About the application

Application number: 2023/90576	
What is the application for?:	Erection of extensions and refurbishment of tea room and changing rooms, upgrade
Address of the site or building:	East Bierley Cricket Club, South View Road, East Bierley, BD4 6PJ
Postcode:	BD4 6PJ

Project Name:	
E.B.C.C	
Drawing Title:	
Site Plan- Proposed

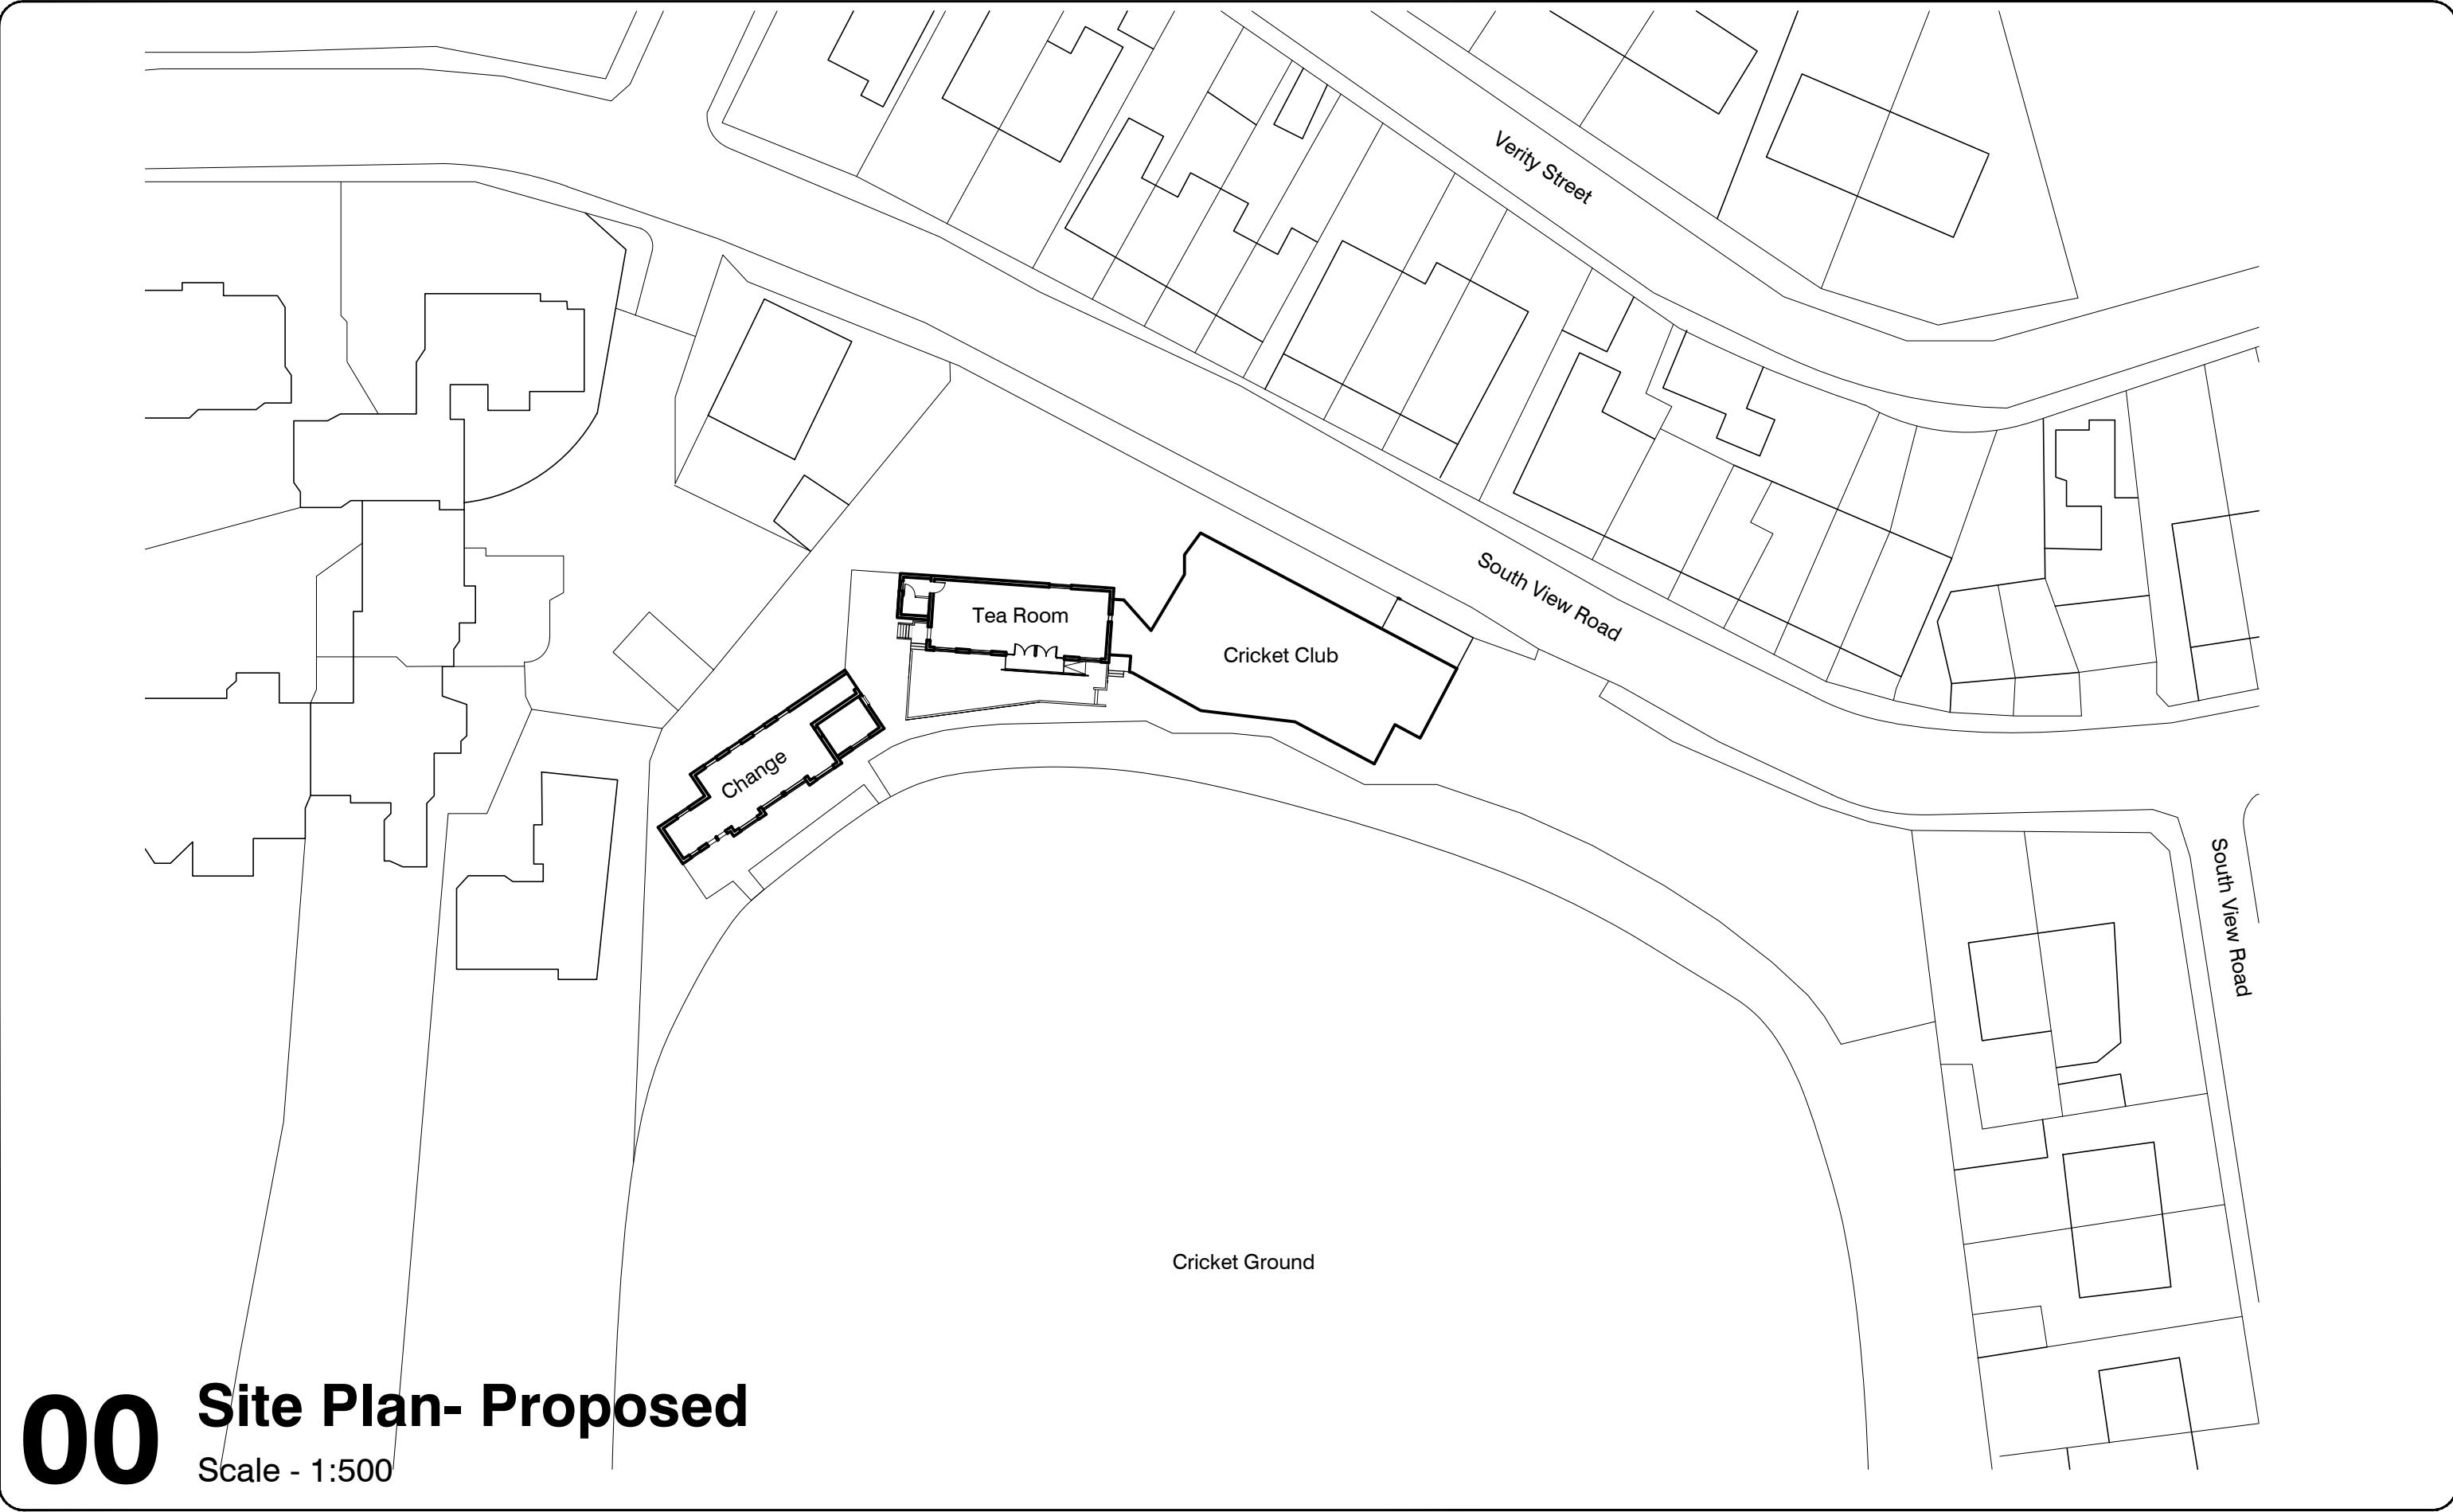
Type of comment: An objection	
Do you wish your comments to be published on the website anonymously?	Yes
<p>Our objection is primarily directed to the extension of the rear of the tea room. If a decking is put out with tables and chairs it will severely affect our, and our immediate neighbours', privacy as our homes can be directly looked into; being immediately opposite. Also we are concerned regarding noise levels. We would like to see privacy/sound control measures included, eg 6ft fence on the perimeter wall, in order to mask additional noise and provide a privacy barrier between our homes and the decking.</p> <p>With improved facilities will come additional vehicles. The plans state there is plenty of parking on the streets; however there is not. More spaces need to be provided in the grounds. Residents already have difficulty parking near to their homes and any increased parking causes increased traffic issues due to it being an overly busy road. We would like to see extra parking within the cricket grounds being part of the planning application.</p>
